URBAN DESIGN REVIEW PANEL REPORT

Project:	2213 – 1657 Carling Avenue	Date:	01 October 2024
Hearing Date:	07 September 2023	Pages:	48
Comments Received:	10 October 2023		
File No.	PC2024-0317 / D02-02-24-0032

RESPONSE TO UDRP RECOMMENDATIONS

Project:	2213 – 1657 Carling Avenue	Date:	16 October 2023
Hearing Date:	07 September 2023	Pages:	5
Comment Received:	10 October 2023

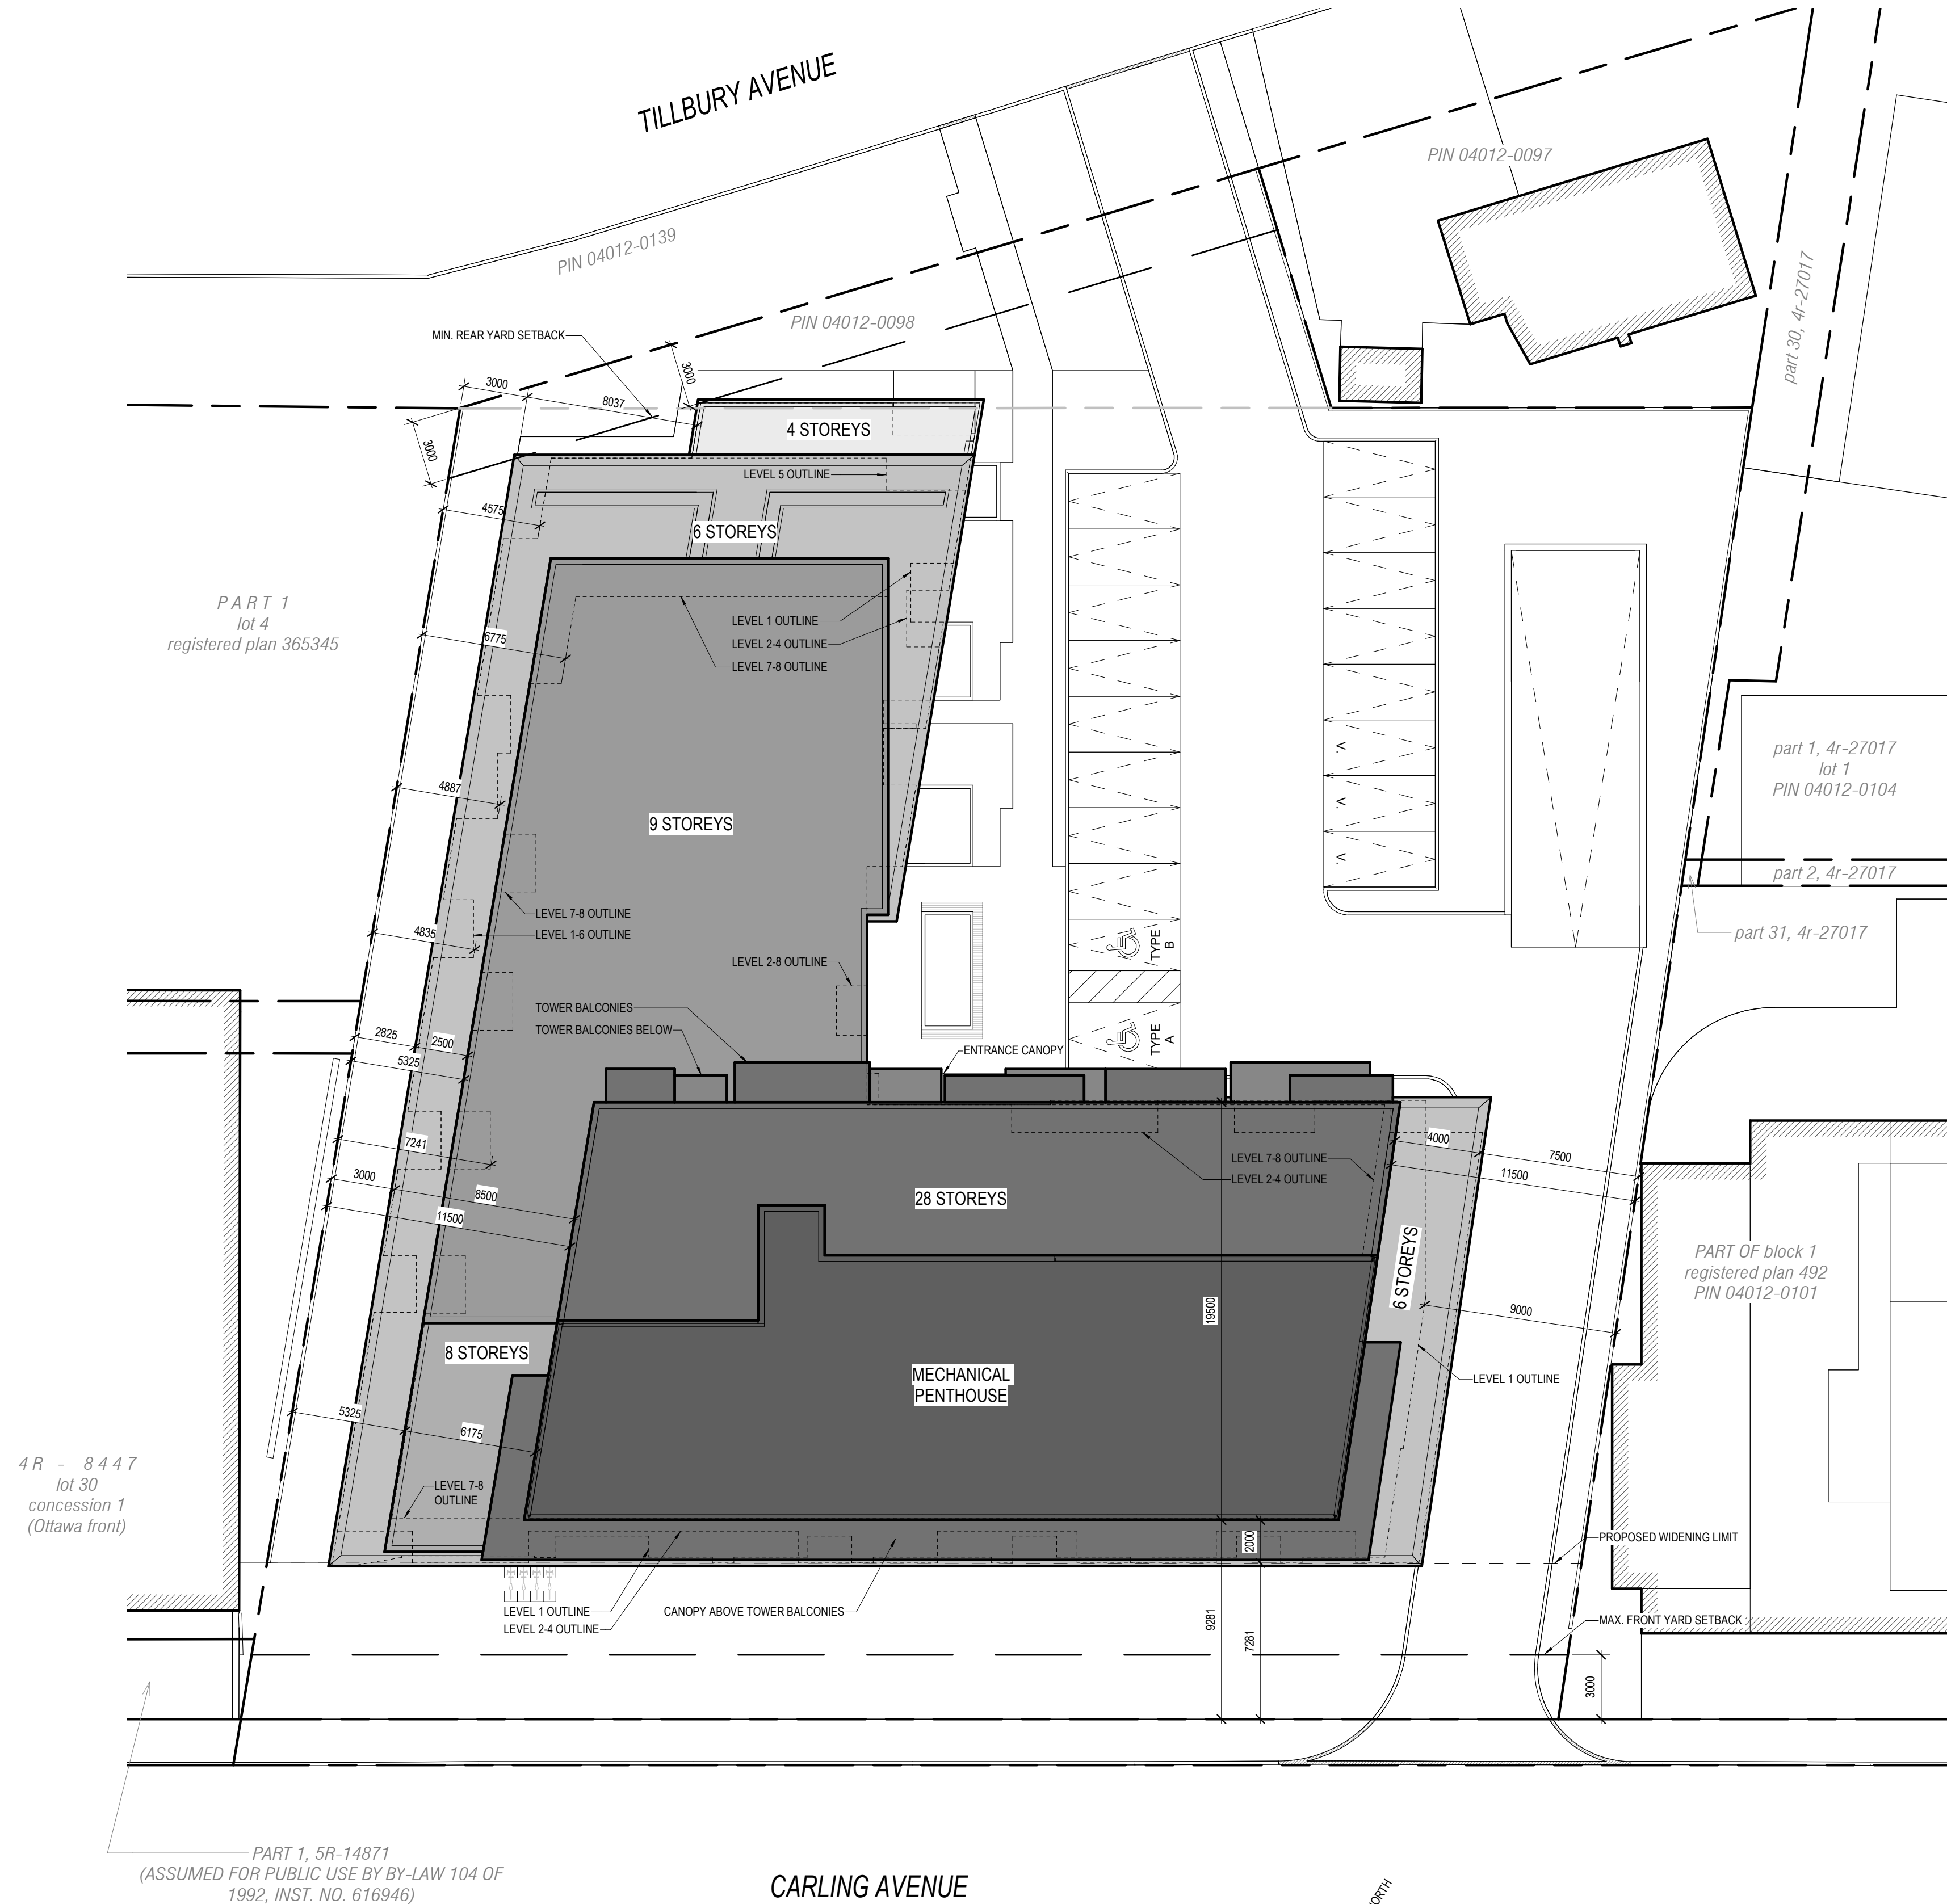
- The Panel has concerns with the 3m side-yard setback being proposed along the western property line.*

- *The Panel recommends reducing the surface parking area as much as possible.*
Noted, however the building does contain 4 retail units along with 390 units, so there will be demand for short term parking, as well as pick-up and drop off spaces. The surface parking as designed is completely shielded from both Carling and Tillbury.

- *The Panel appreciates the description in the presentation of this parking area as a courtyard space, however what is currently proposed reads as a parking lot.*

- *Consider adding more landscaping in order to create a courtyard space. A lush courtyard space will also create a buffer from Tillbury Avenue. The courtyard design should be explored further in order to fulfill the description and intended vision for that space.*

- *The Panel recommends implementing a surface treatment in the ‘courtyard’ space that is more consistent with a pedestrian-first space.*

- *Consider blurring the lines between the pedestrian landscaped portion and the vehicular space by using paver treatments and landscaping as a means of creating a more pedestrian-first environment overall.*

- *Consider designing the forecourt area as a woonerf style courtyard.*

- *Consider reducing the number of surface parking spaces proposed.*

The 3m interior side yard setback is along the face of the building in areas intended for bedrooms. Living spaces will be adjacent the recessed patios and balconies which offer an additional 1.5m setback. A 4.5m setback is a very liveable and will offer no ill effects on the few units that have this exposure. Keep in mind

as well that the development on the neighboring property to the east has much tighter interior side yard setbacks that go down to zero in some locations.

We are confused by this comment as we described in detail the landscaping shown in the design package. The building has a very generous setback from Tillbury in order to create a park space and this park is then carried into the courtyard of the building. This includes features such as raised planters, benches and other elements of outdoor furniture. Separating the parking from the ramp is another area of planting which is meant to obstruct the view of the ramp and will include small trees and taller shrubs.

While we have yet to complete a landscape plan, this will be done for the site plan control submission, where we will also provide more specifics of the specific planting being proposed to ensure that this space feels like a courtyard and not simply like a parking lot.

The specifics of the hard landscaping will be further developed during the site plan control submission, however there are concerns over cost and long-term wear related to using paving stones.

This can be considered as we develop the landscape design further.

We foresee a practical need for these surface parking spaces to properly serve the building. That said, we will look to see if we can remove one or two parking spaces in the future.

FLOOR PLAN LEVEL 01

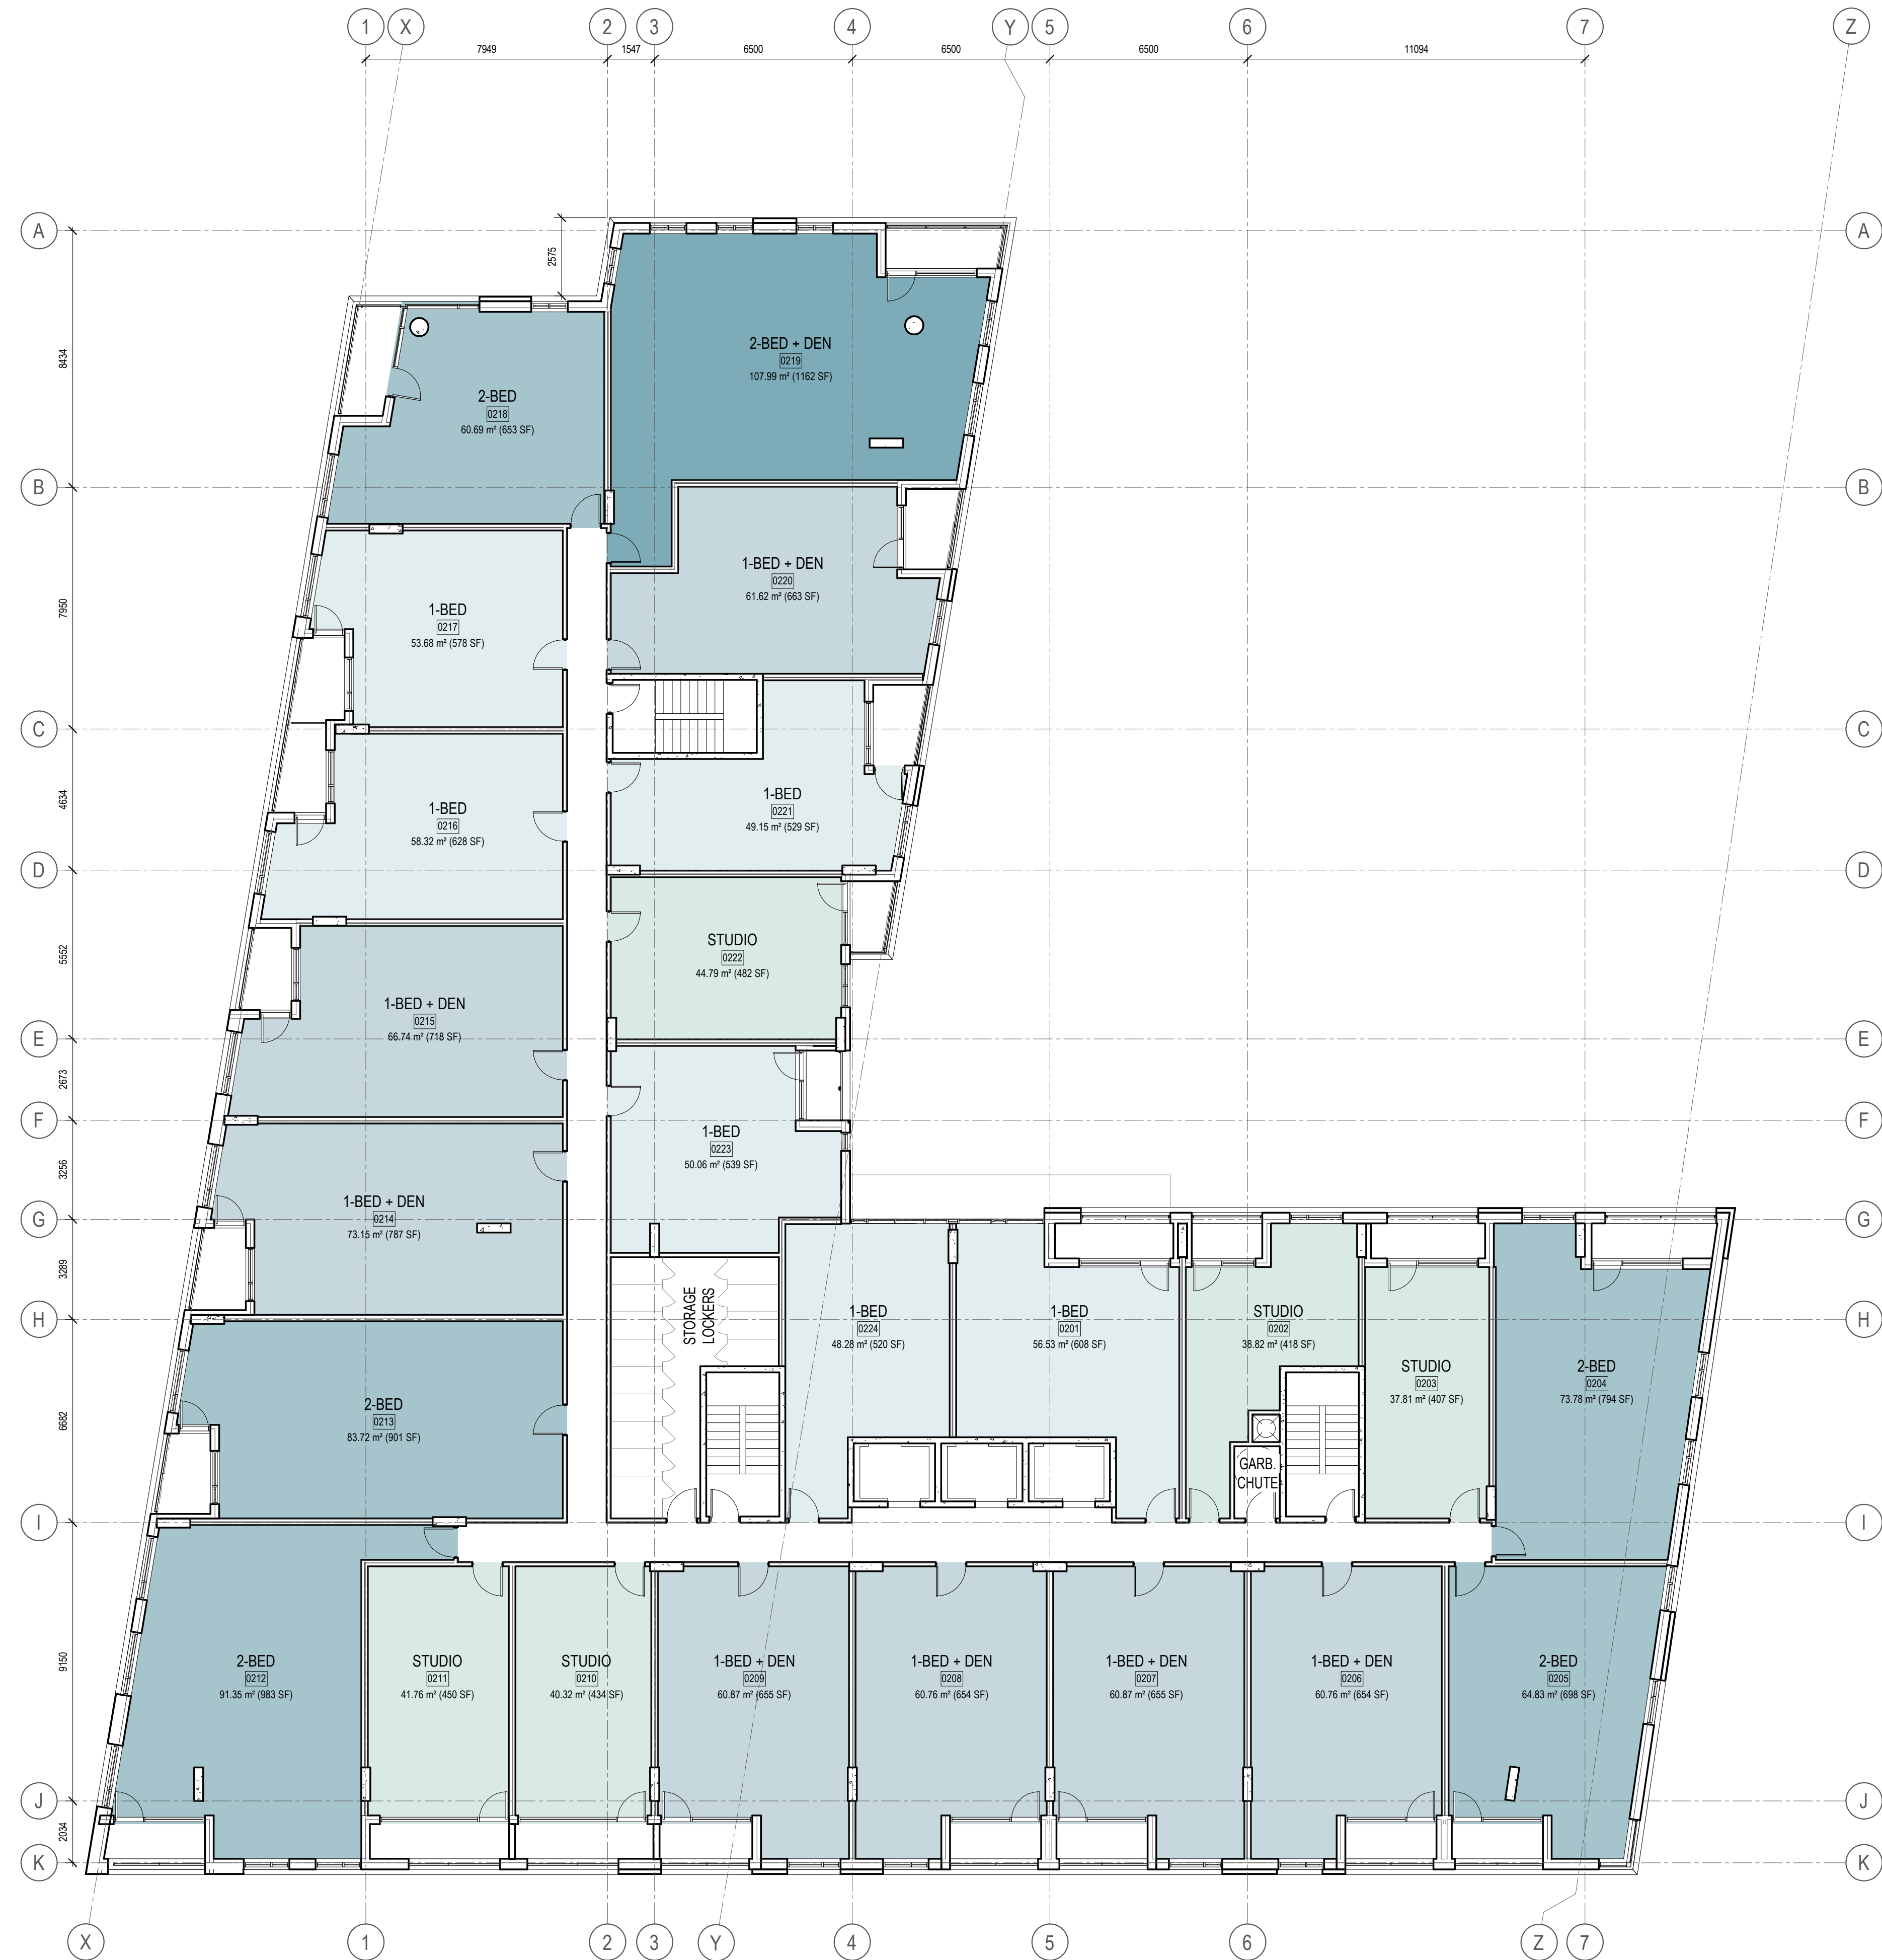
- The Panel highly recommends pursuing a generous through lobby from the south-west corner of the building (where amenity workspaces are) to enhance and improve the building's access and presence along Carling Avenue.

- Consider merging the amenity workspaces with a grander lobby area to enhance that through lobby experience as much as possible.
Noted.
- The Panel recommends ensuring that the podium heights and street-wall align with the adjacent existing and proposed buildings.
Noted, the podium and street-wall are in alignment with the development at 1655 Carling, immediately to the east of the subject site.

- The Panel recommends providing more depth to the commercial spaces to help them be successful.
Noted.
- The Panel recommends removing the amenity space on the ground floor or merging it with a through-lobby entrance at the corner of the building.

- Consider moving the bike storage space to the west side of the building, closer to Carling Avenue and creating a through-lobby area.
Noted.
 - Consider placing any ground floor amenity space on the courtyard/forecourt, potentially swapping with the bike storage area.
We strongly disagree with the suggestion to position a bicycle storage room along the street frontage instead of an amenity space that is designed to promote interaction with the street. Note that the primary outdoor amenity space for the building will be the terrace on the 10th floor facing north, which also features an indoor amenity room. The courtyard space at the entrance to the building is meant more to create a sense of arrival and to facilitate departure.
